From: Sue Howell
Sent: 24 July 2014 16:29
To: Planning.Responses
Subject: RE: Planning Consultation on: LU/118/14/PL

Comment from Greenspace

APPLICATION LU/118/14/PL

Description of Works: Change of use & extension of part of former office building to a G P Practice with associated parking, landscaping & highway works.

client	Community Solutions	Coastal West Sussex CCG
project	New GP Surgery, Uththampton	East Wing 'Enterprise Hub'
file	Site Plan - proposed	
date	Feb 2014	1:200
scale	paper	drawn
checked	A1	SVR
33157	06	F

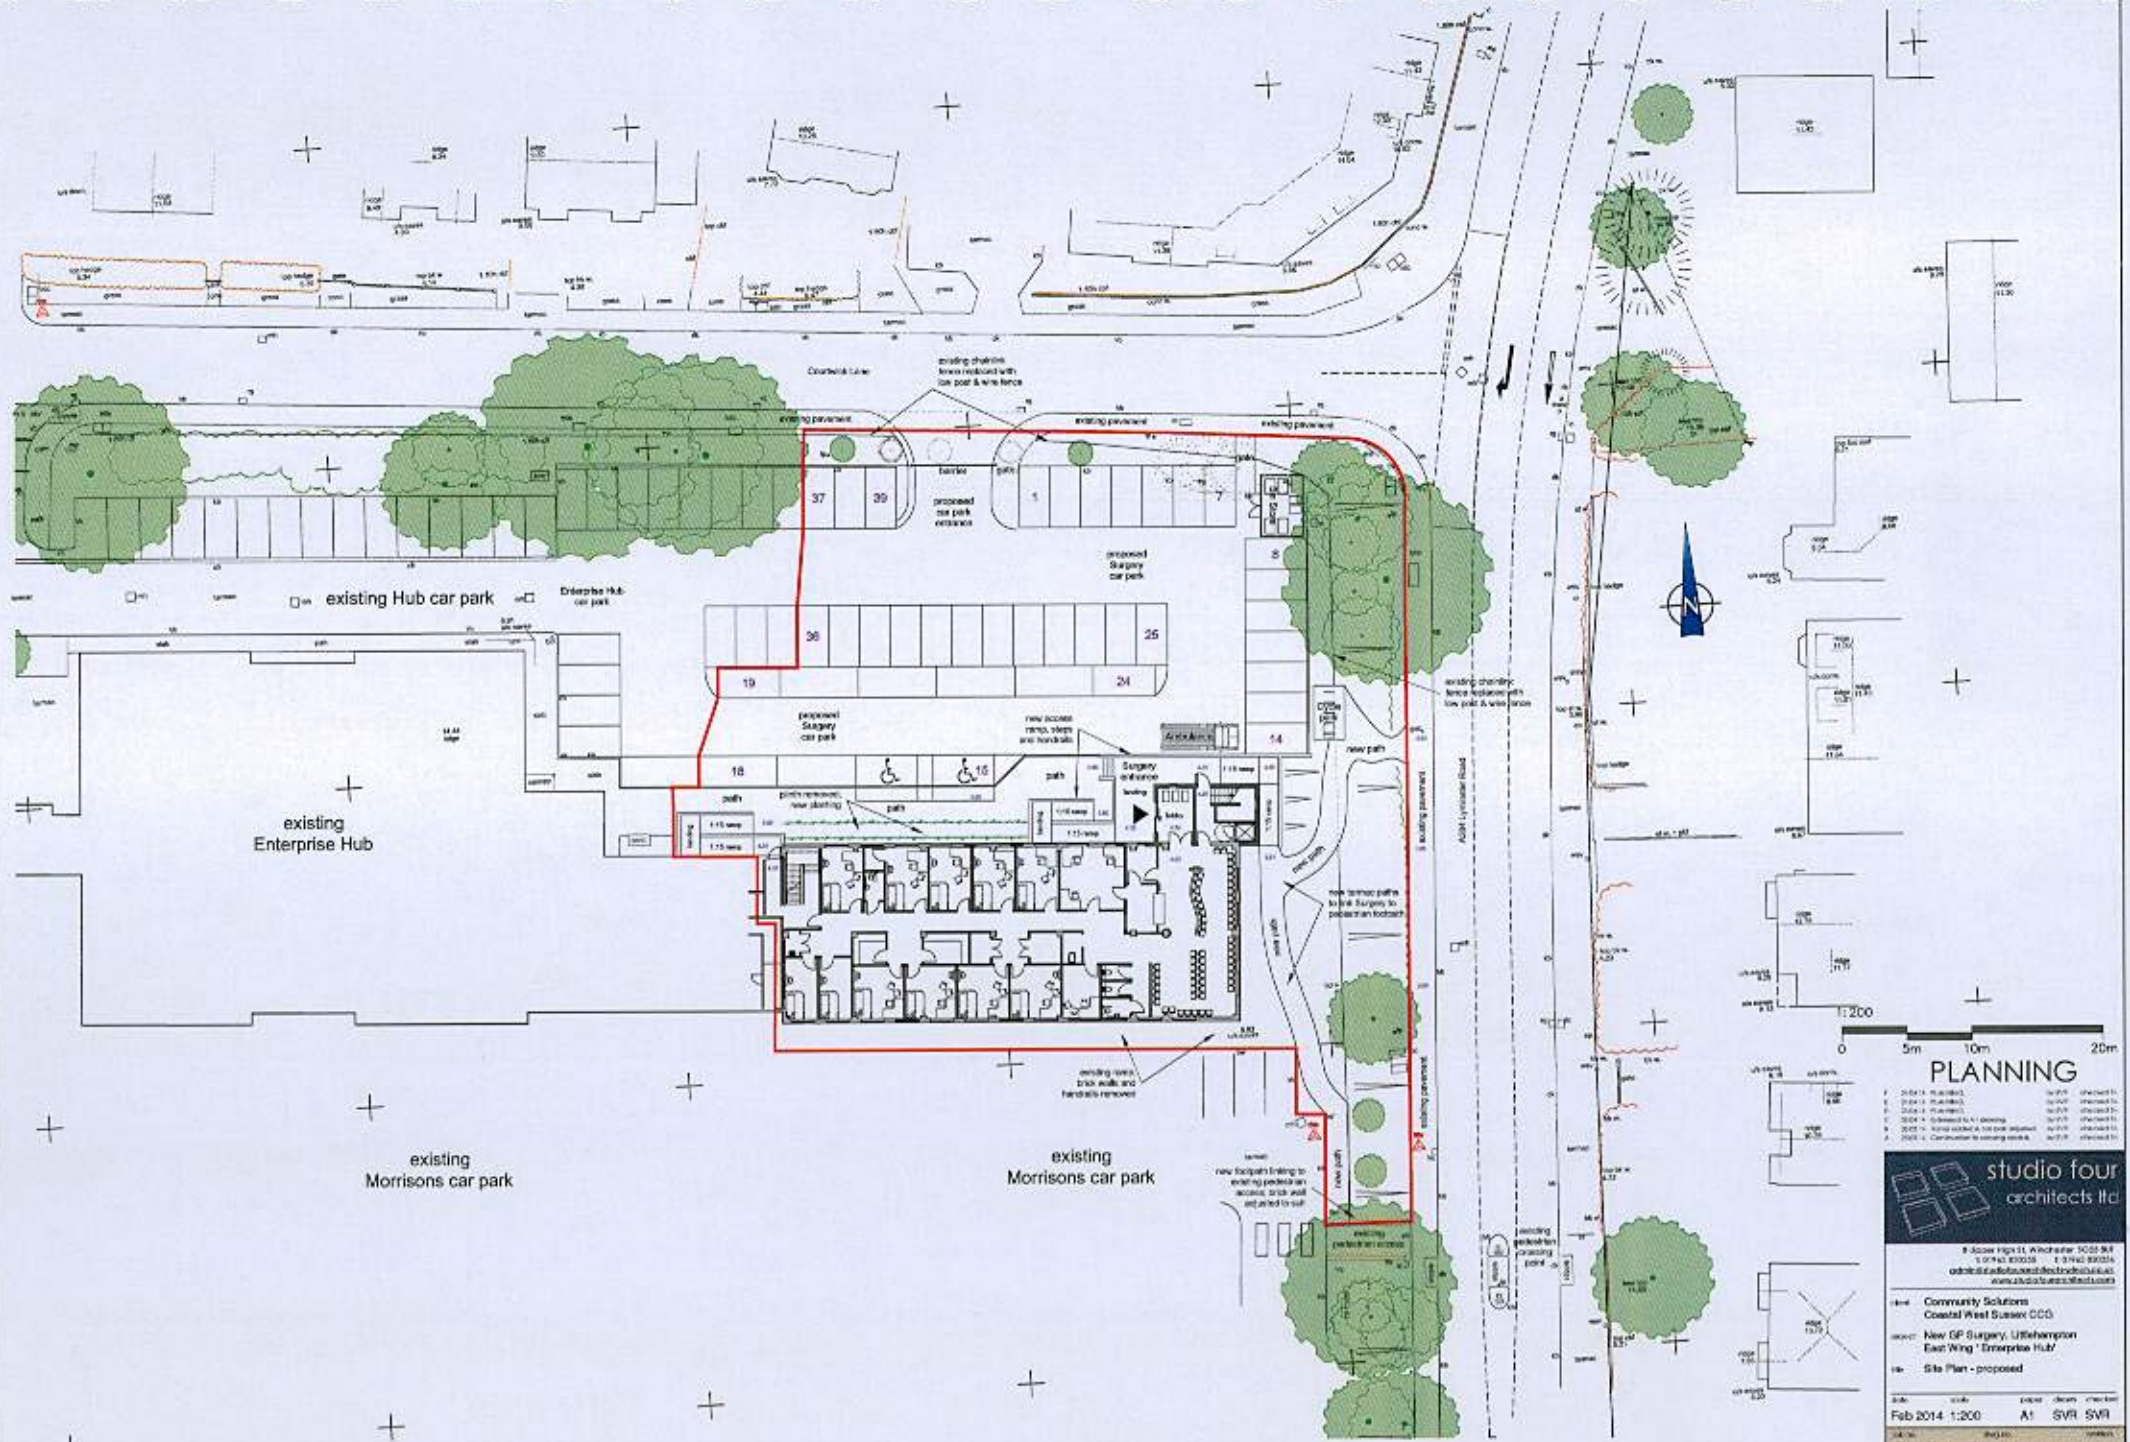
The applicants Arboricultural Development Statement page 12, 17.0 details that the soft landscaping is to be dealt with as a reserved matter, and therefore no further details relating to the mitigation have been submitted at this stage. This information will need to include a landscape layout which would need to detail hard and soft landscaping showing in plan form the proposed planting which would be in mitigation for that which is shown for removal. The detail would need to include species choice, planting densities and size at time of planting.

We would recommend that this information is submitted and approved or conditioned as a reserve matter prior to any decision being made on this application.

10232
Surgery, Courtwick Lane, Littlehampton
Tree Survey Plan

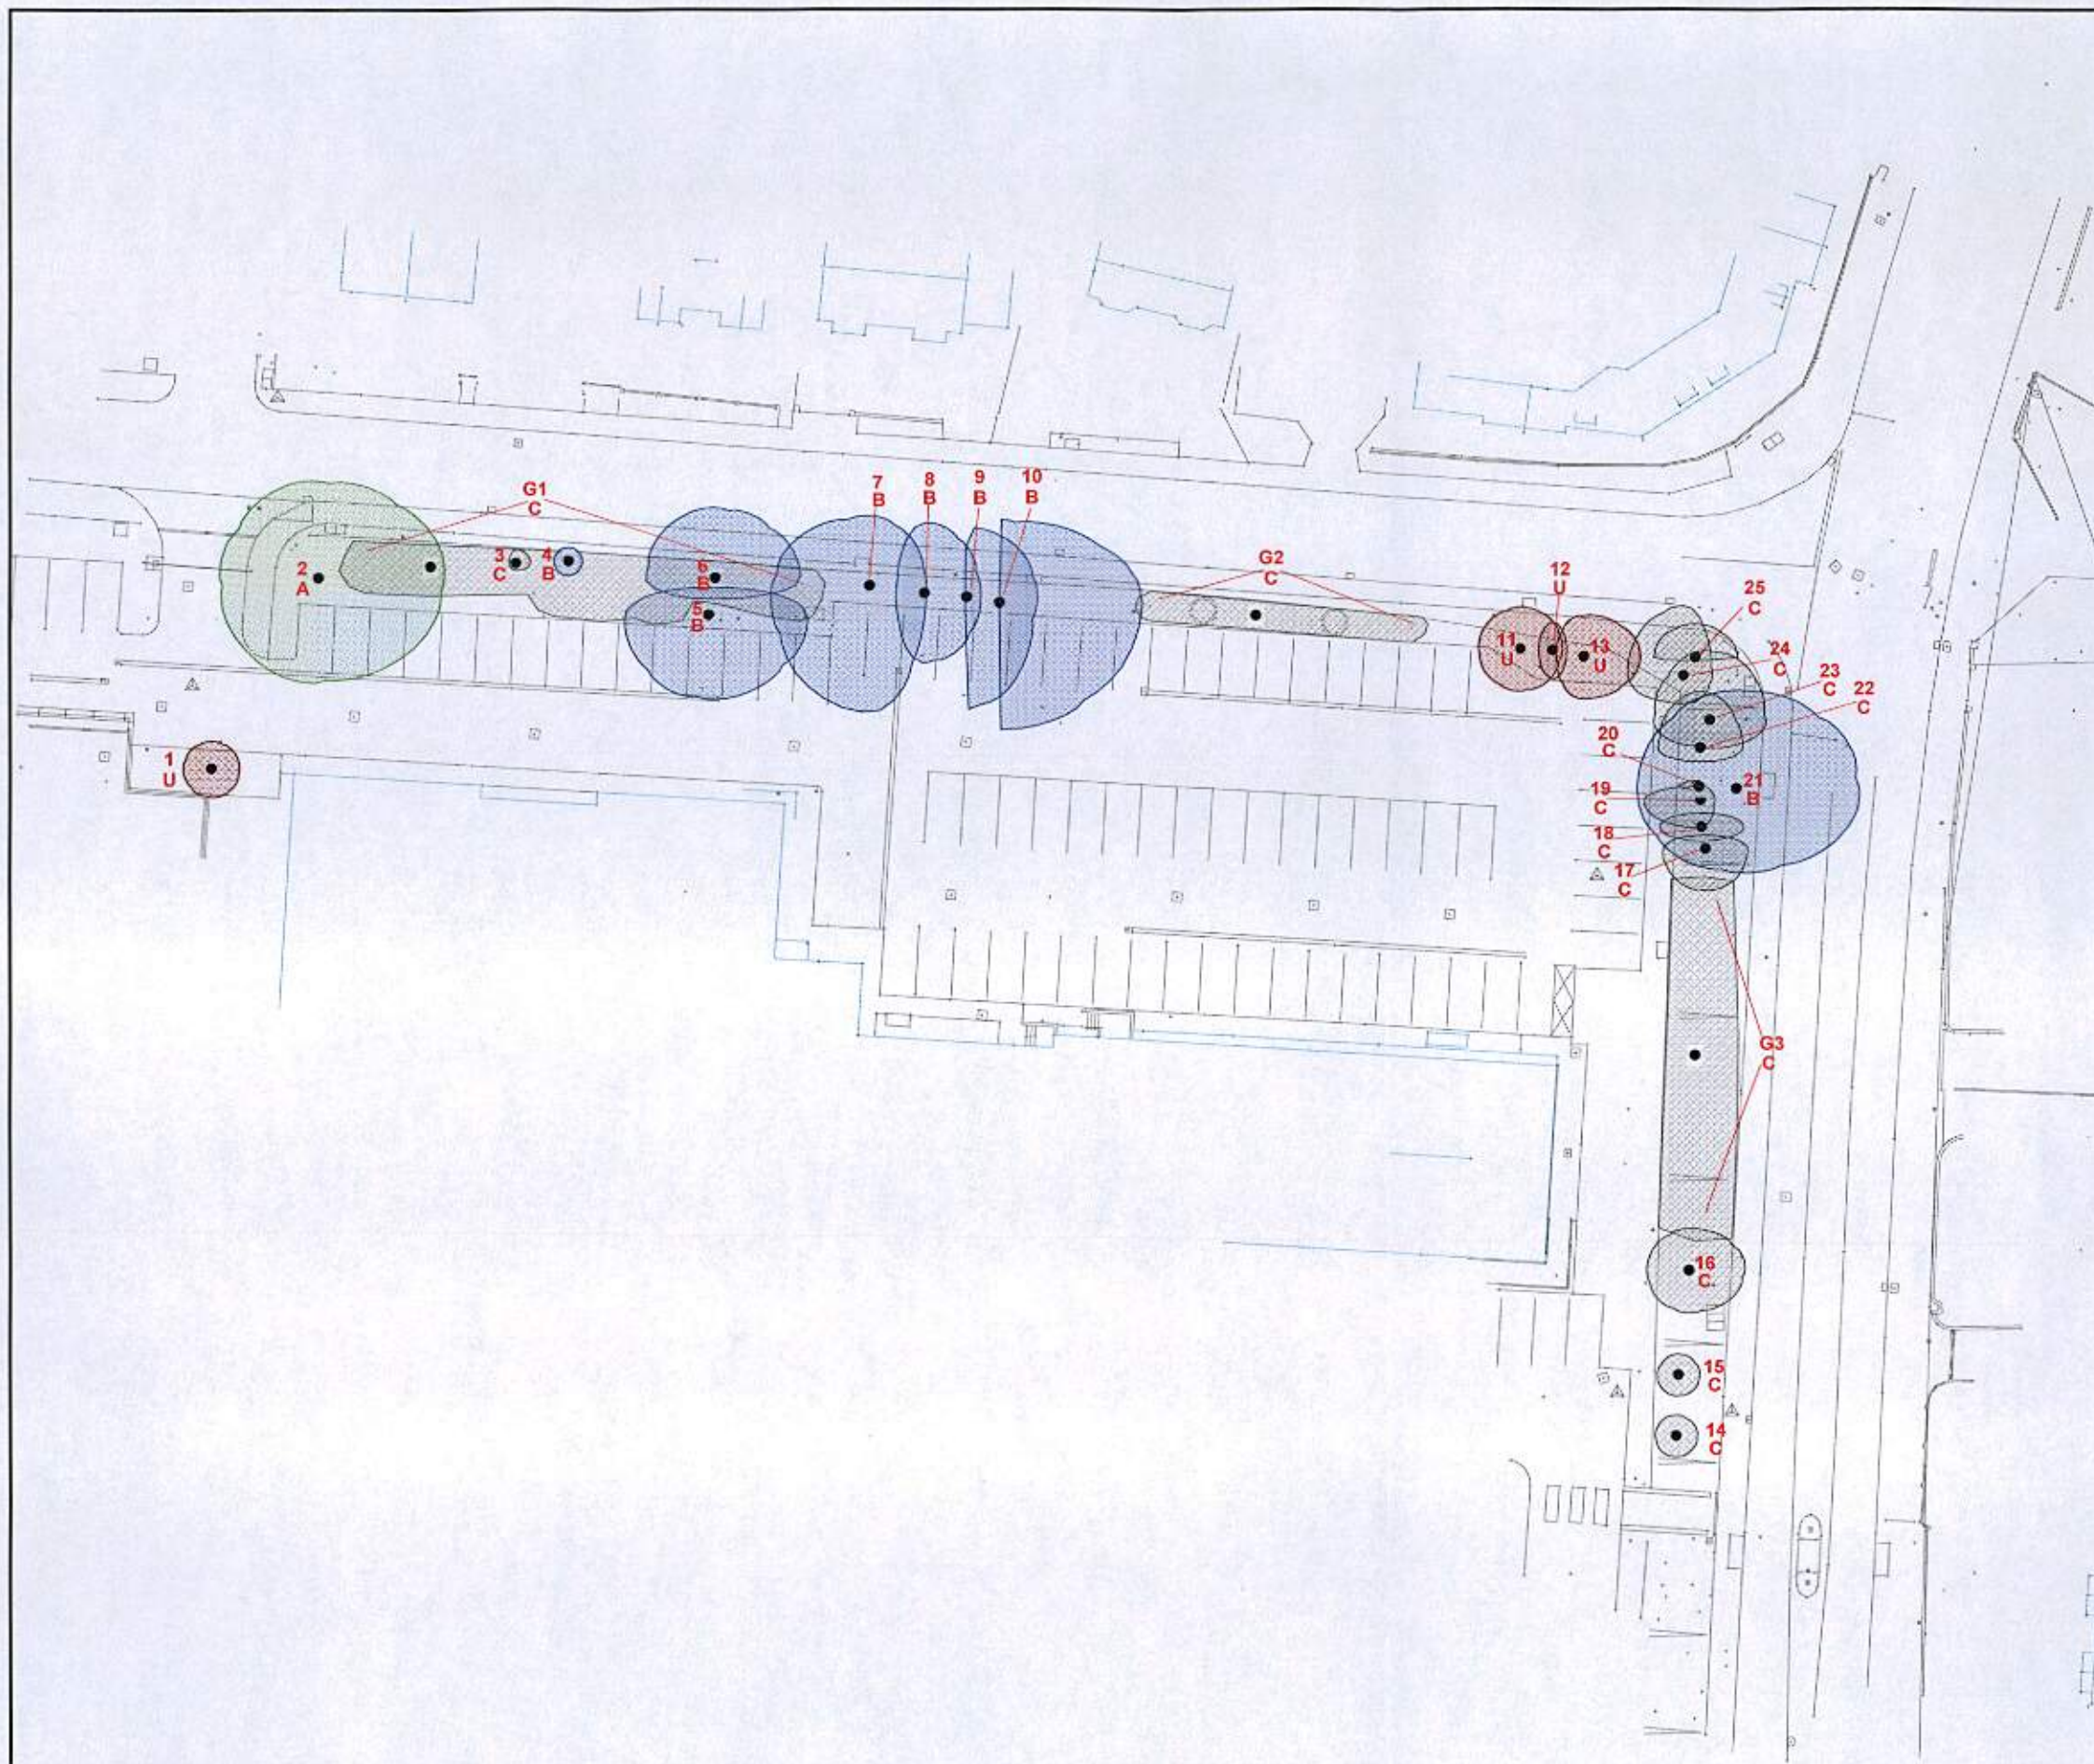
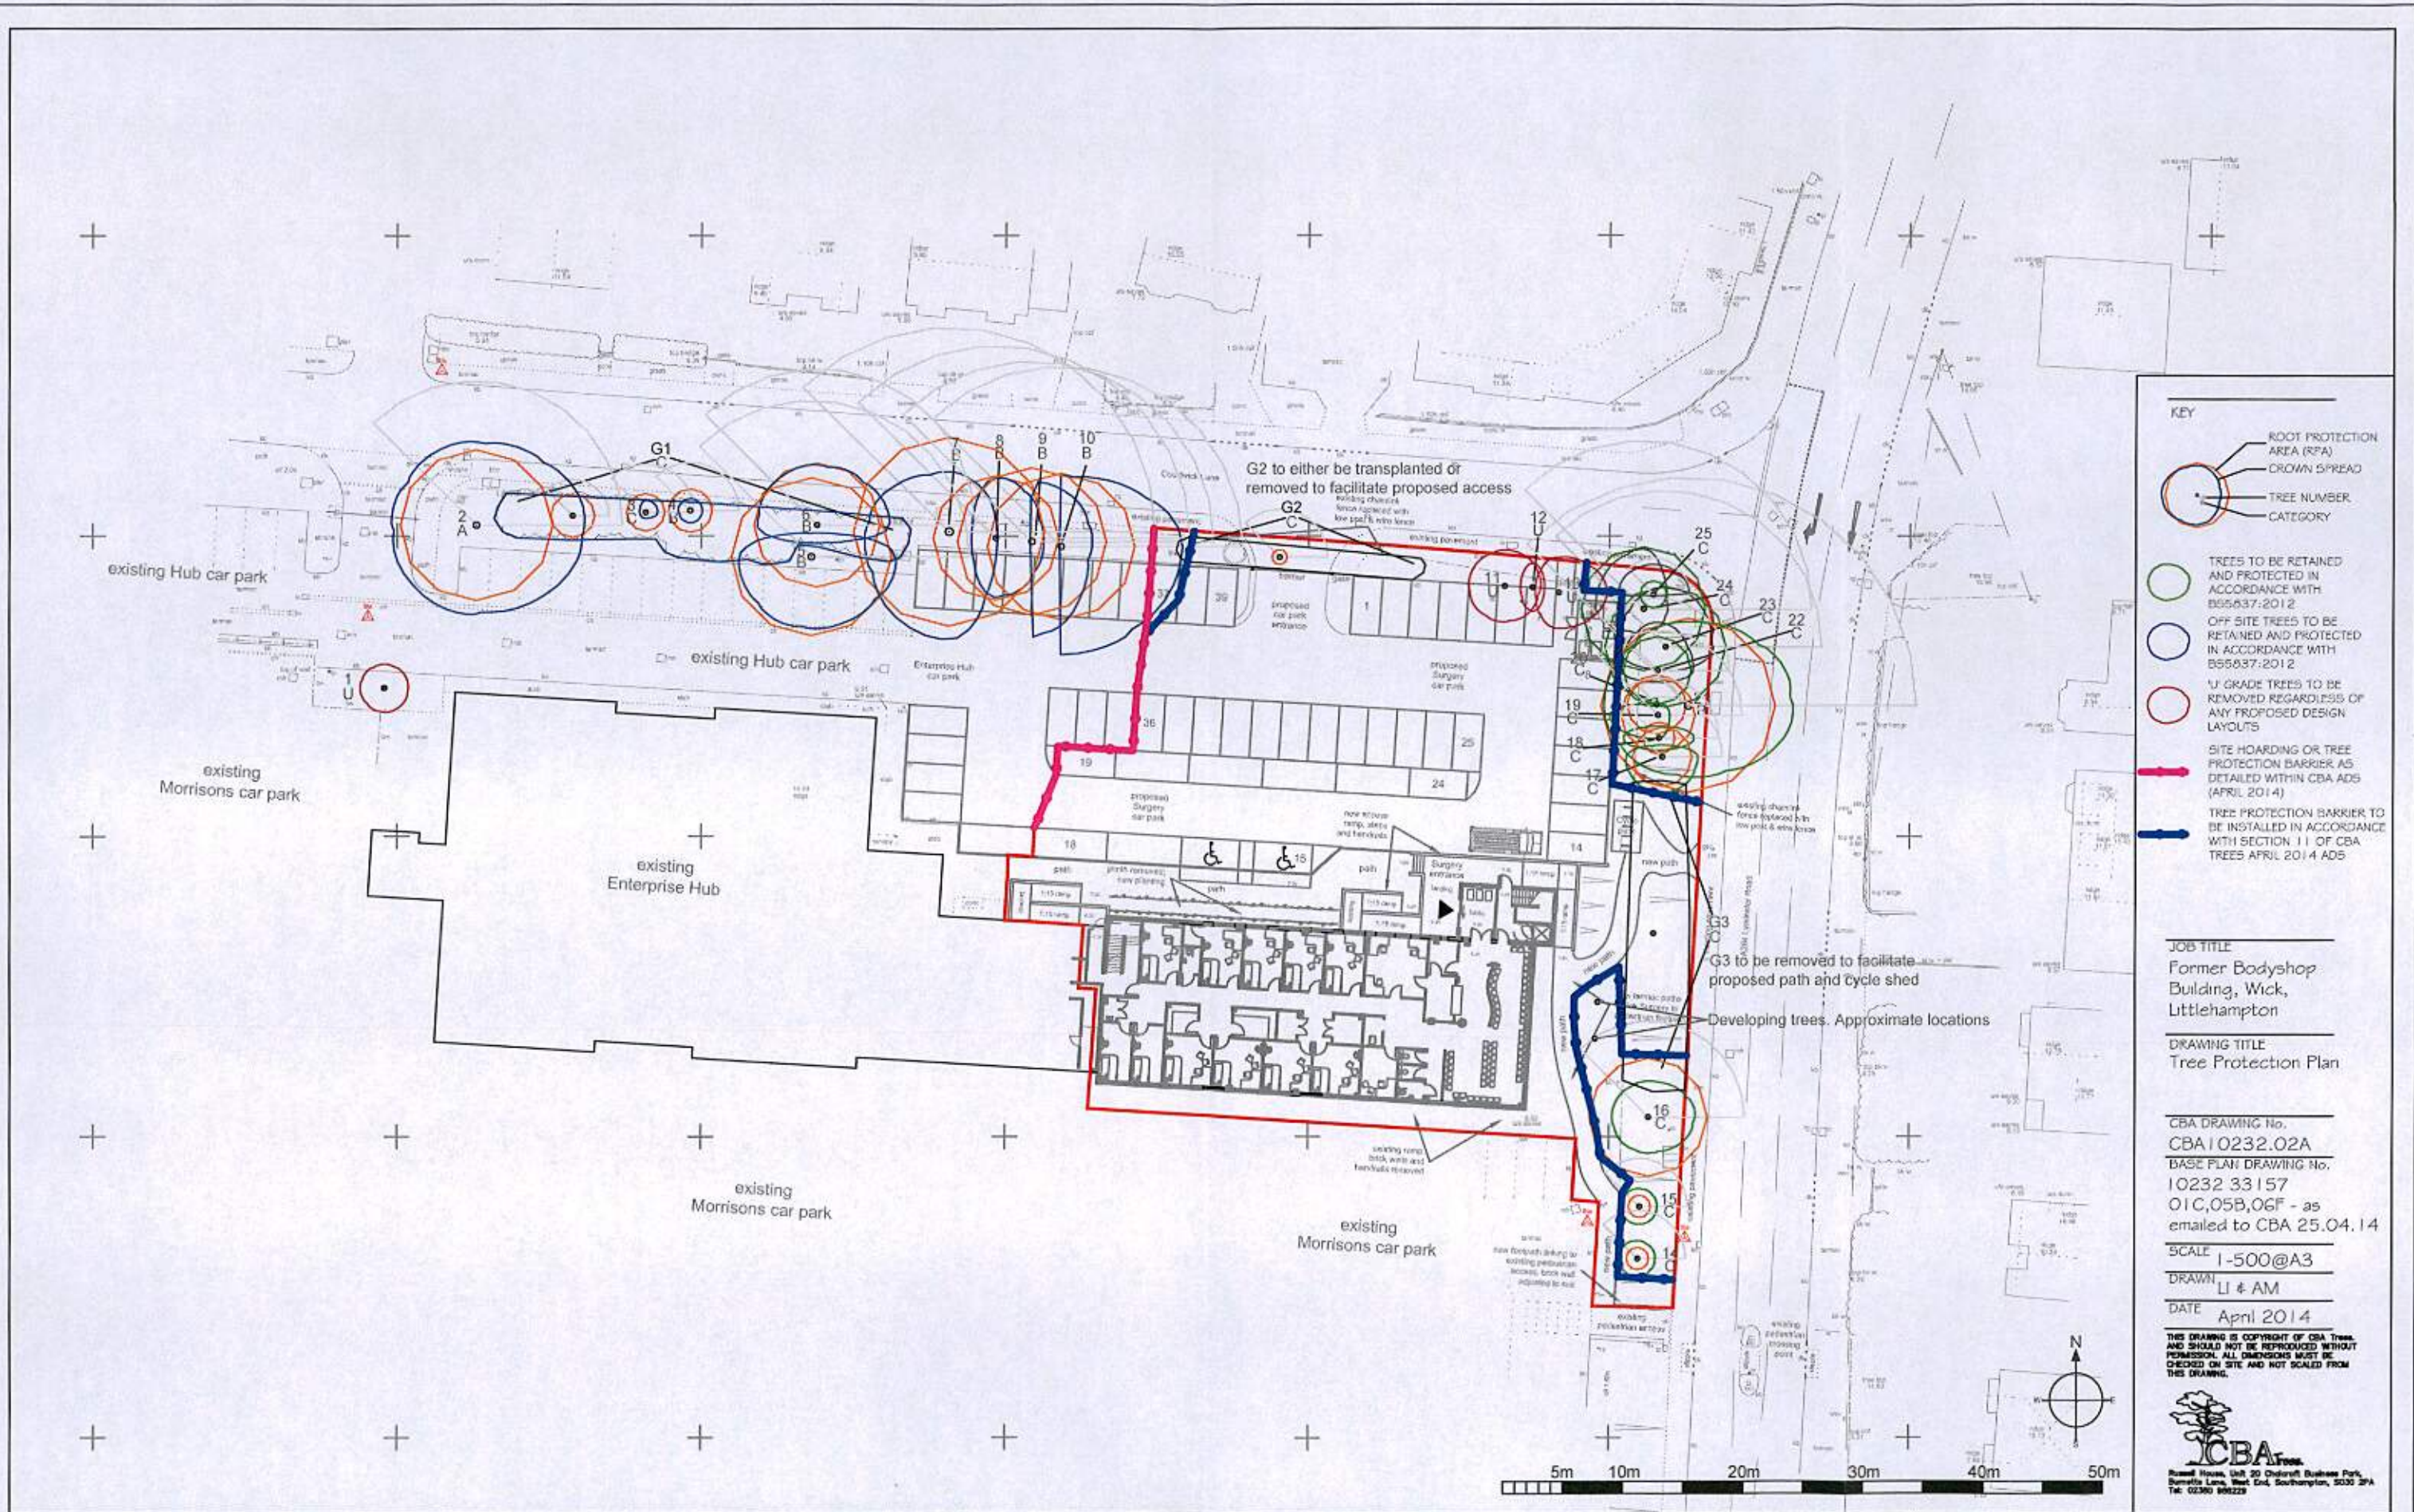
The detail submitted within this application gives effective tree schedule detail along with root protection details that conform to BS5837:2012 Trees in relation to design, demolition and construction recommendations. However any consent for tree works/removal must first be at the agreement/approval of Arun District Councils Tree Officer.
